DRB Application No.: 05DRB-00967 (P&F)

Project Name: LANDS OF GARCIA & FAJARDO

Project Number: 1004255
Application Number: 05DRB-00967

RE: Lands of Garcia & Fajardo, Tract -2/minor plat

PLAT OF TRACTS A-2-A & A-2-B LANDS OF GARCIA AND FAJARDO

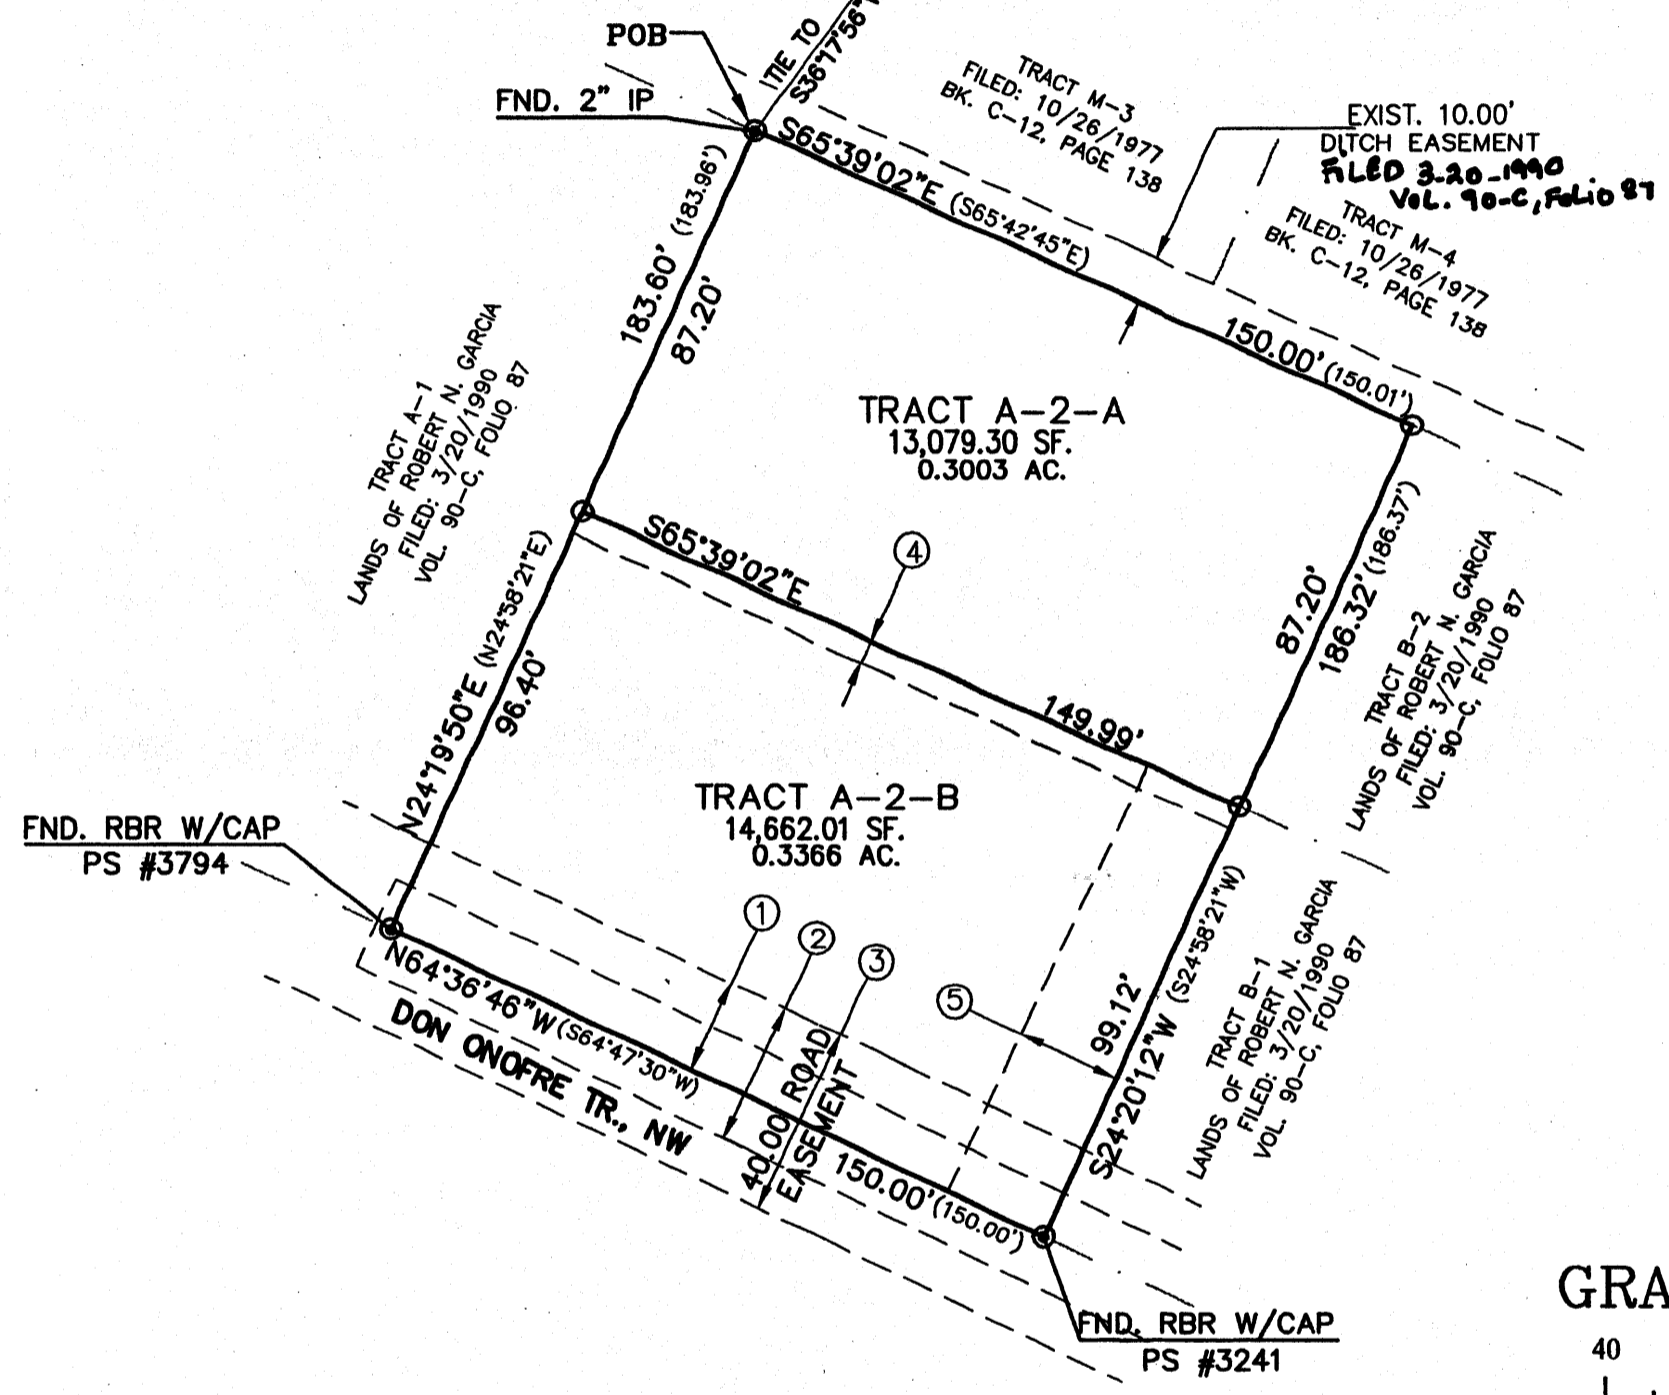
- TRANSPORTATION: Private or public road
- agreement
-
-
-
-
- UTILITIES:
-
-
-
-
- CITY ENGINEER / AMAFCA:
-
-
-
- PARKS / CIP:
-
-
-
- PLANNING (Last to sign): Set back
- AGIS
-
-

No objection provided the required setbacks for RA2 zoning are met with the lot split.

AGIS dxf approval is required for Planning to sign the plat.
